**Consultation Response from KC,  
Highways Development Management****2024/91030 Wonderland, Upper Hagg Road, Thongsbridge, Holmfirth, HD9 3TF****Change of use from art studio to therapy unit****Date Responded: 28-502024.****Responding Officer: Mark Berry.****Responding Ref: 3-48-21.**

Existing Block Plan

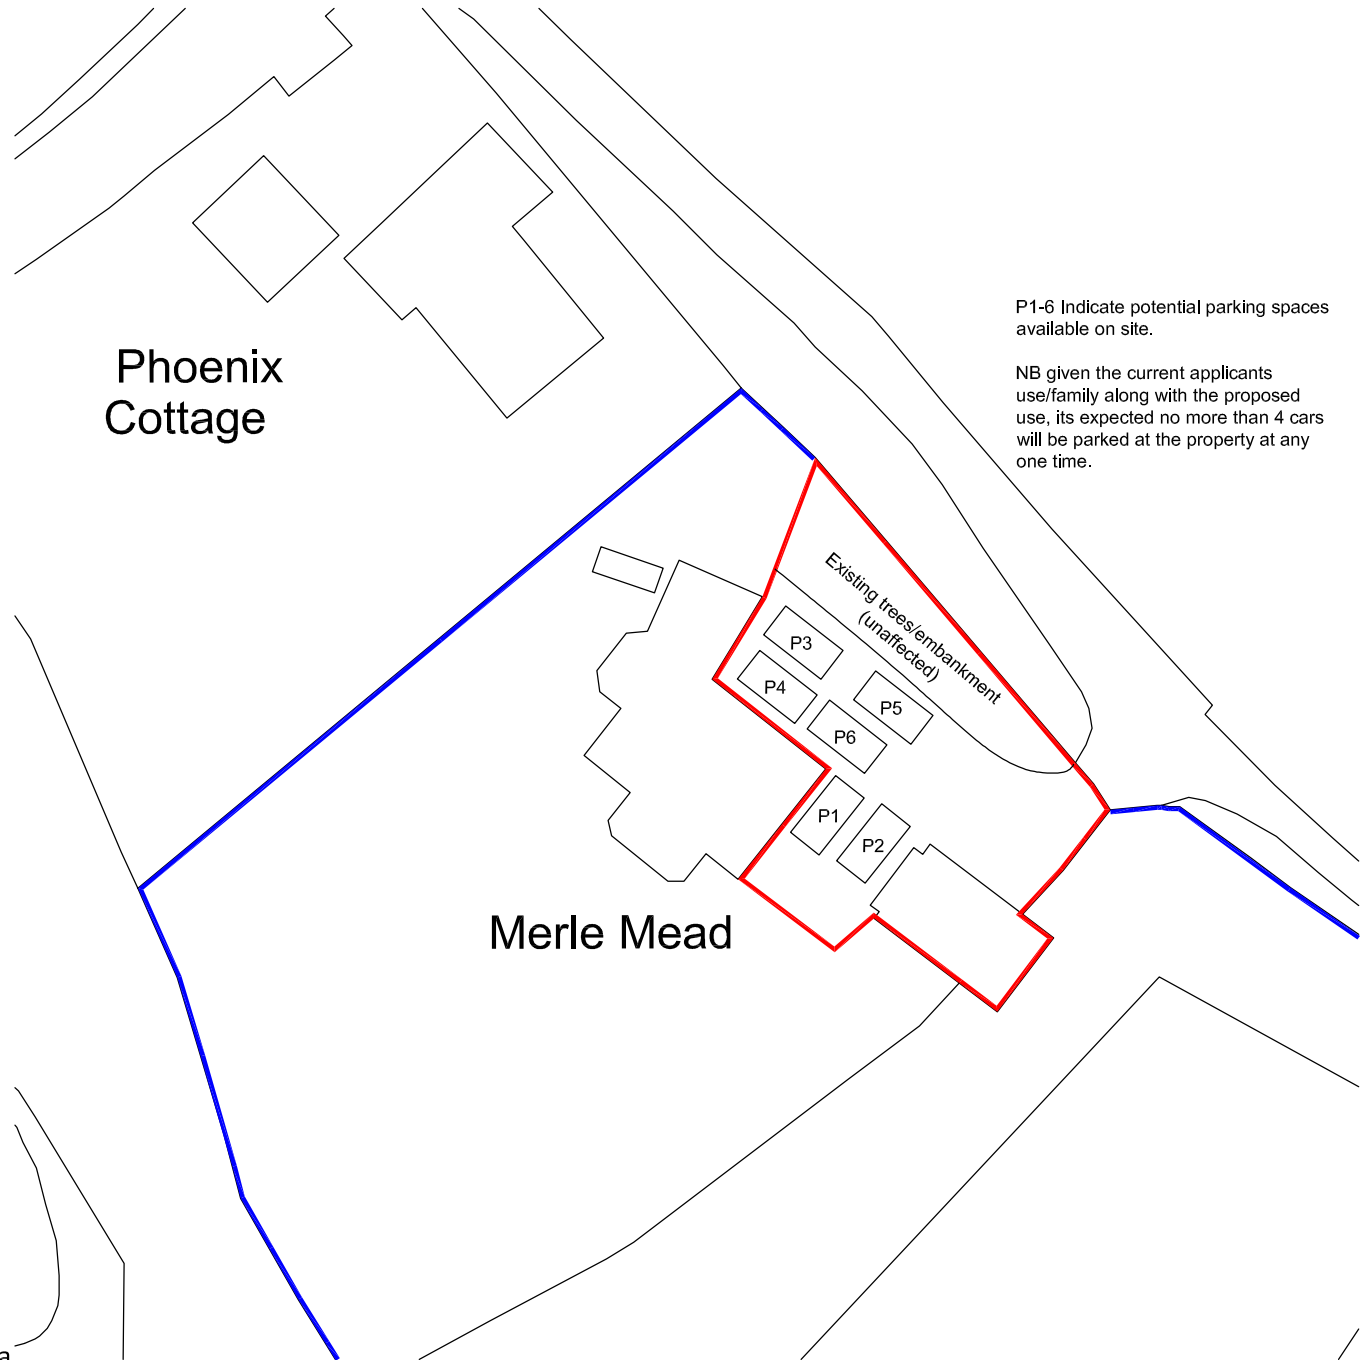
Given that this proposal utilises an existing access, sufficient off-street parking with internal vehicle turning is provided and the number of vehicle movements is low and are likely to be reduced when compared to the existing use Highways Development Management have no objection to these proposals.
